## Advice to decision maker on coal mining project

### IESC 2020-112: Russell Vale Revised Underground Expansion Project (MP 09\_0013) Expansion

<b>Requesting agency</b>	The New South Wales Department of Planning, Industry and Environment
<b>Date of request</b>	28 January 2020
<b>Date request accepted</b>	29 January 2020
<b>Advice stage</b>	Assessment

Figure 9 | Location of Bulli Seam goaf areas yet to be confirmed as subsided

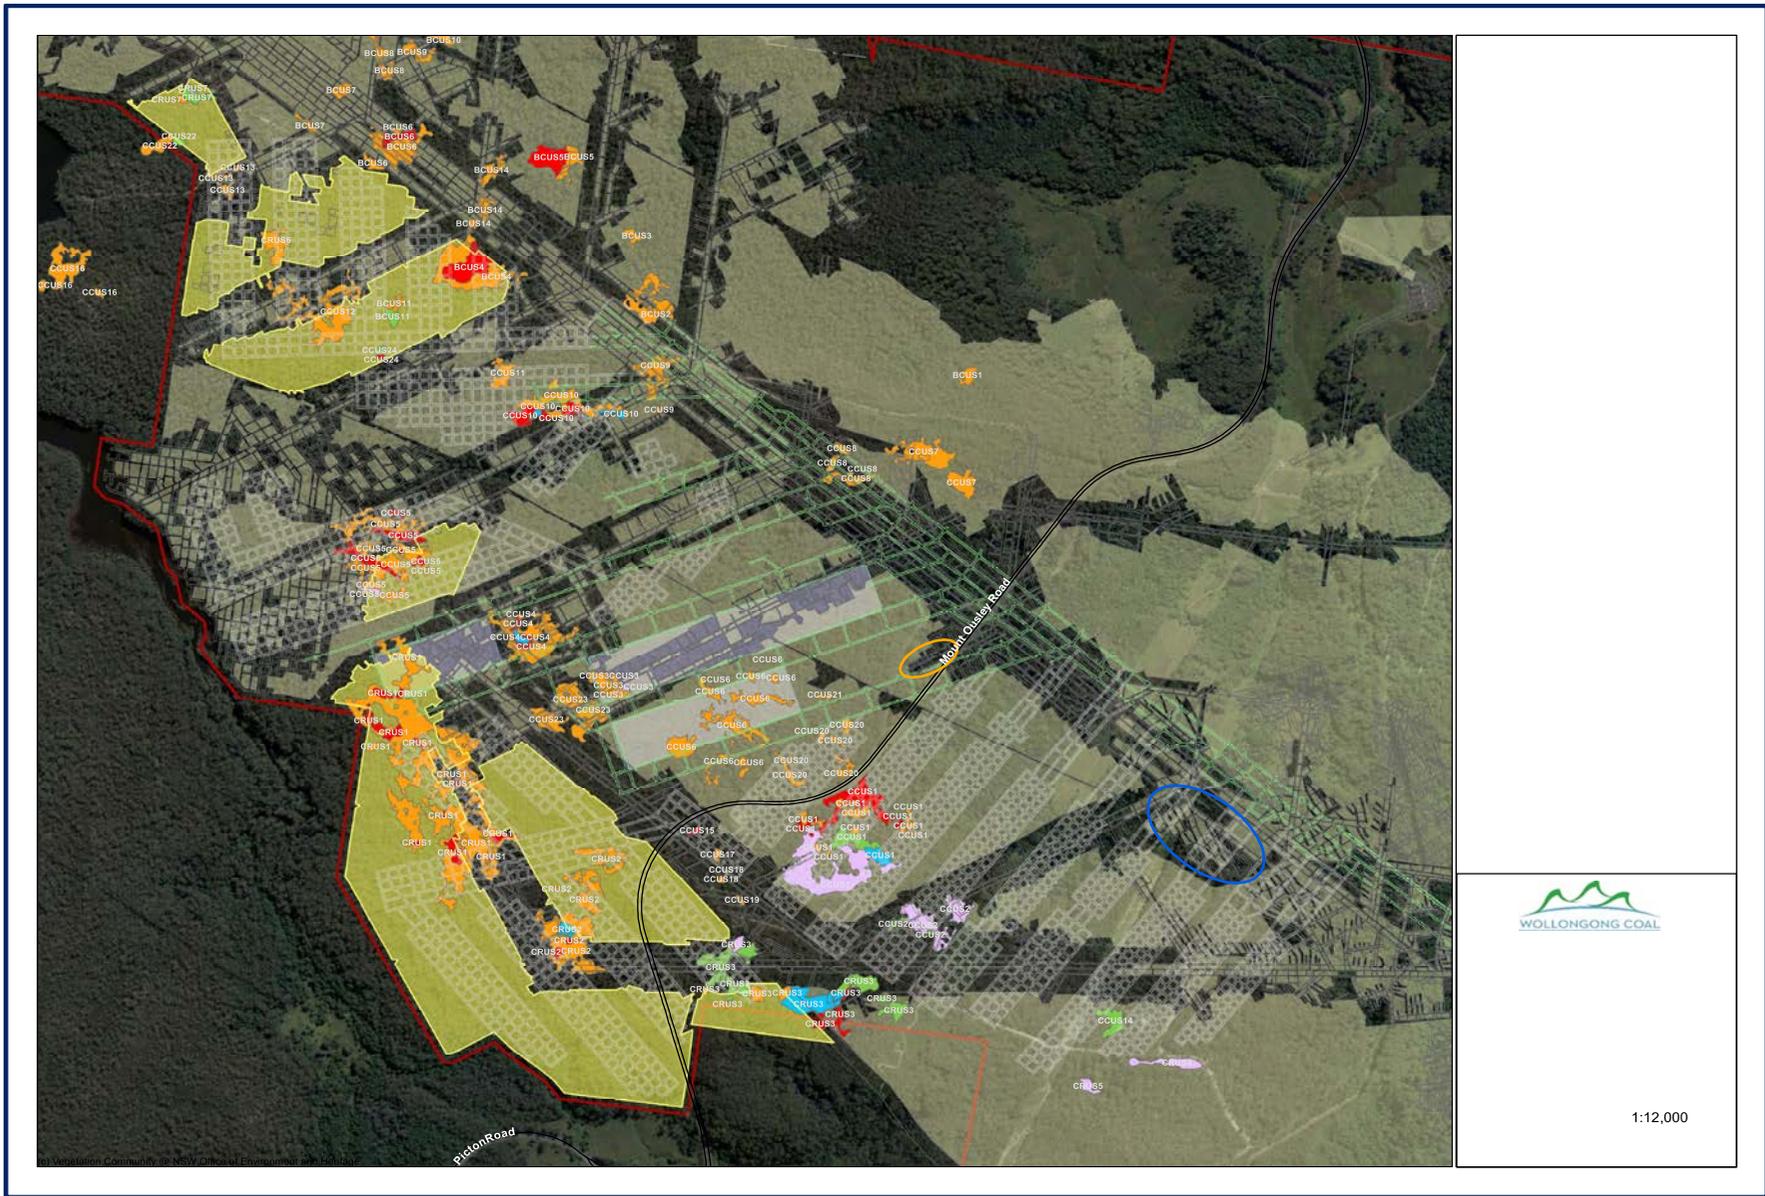
- b. The quantitative assessment provided has highlighted that there is still uncertainty about future subsidence in the Bulli Seam goaf areas and that there remains a potential risk of additional subsidence in the Bulli Seam in seven of the 14 goaf areas whose status has not been confirmed by the proponent (SCT 2020, p. 14). Furthermore the exact locations of the seven goafs, where subsidence is possible, in relation to the Coastal Upland Swamps has not been clearly defined by the proponent; this information is critical to determine the risk from the potential subsidence.
